Consultee Comments for Planning Application 17580/24

Application Number: 17580/24

Address: 165 Tonge Moor Road Bolton BL2 2HR

Proposal: CHANGE OF USE FROM A 6 NO. BEDROOM HOUSE OF MULTIPLE OCCUPANCY (HMO) (USE CLASS C4) INTO A 7 NO. BEDROOM HOUSE OF MULTIPLE OCCUPANCY (HMO) (SUI GENERIS)

5 Proposed Basement
1 : 50

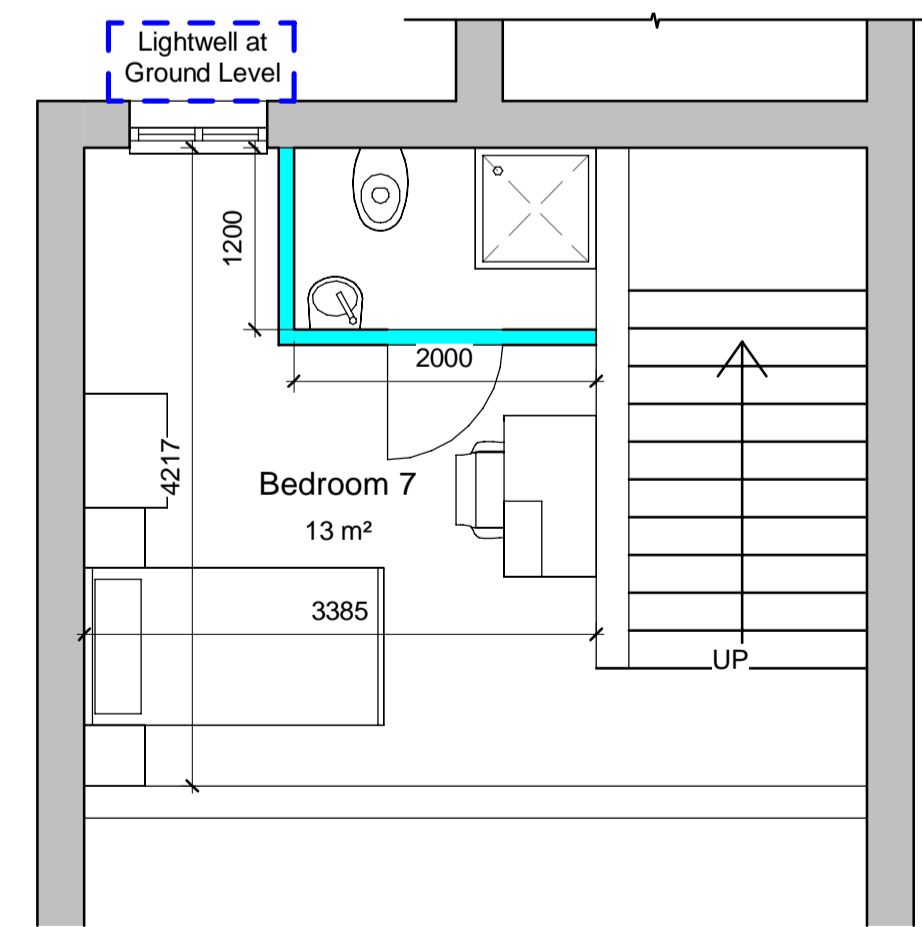
I have no objection to this application in principle. The addition of one bedroom in the basement is the only addition to this HMO however if you are minded to approve this application, I would recommend the inclusion of the following conditions : -

No development shall take place unless and until a scheme to acoustically insulate the floor(s)/ceiling(s) between ground floor and basement in line with guidance in Section 5 of Building Regulations 2014, Approved Document E, has been submitted to and approved by the Local Planning Authority. Such works that form the approved scheme shall be completed before the commencement of the use and retained thereafter.
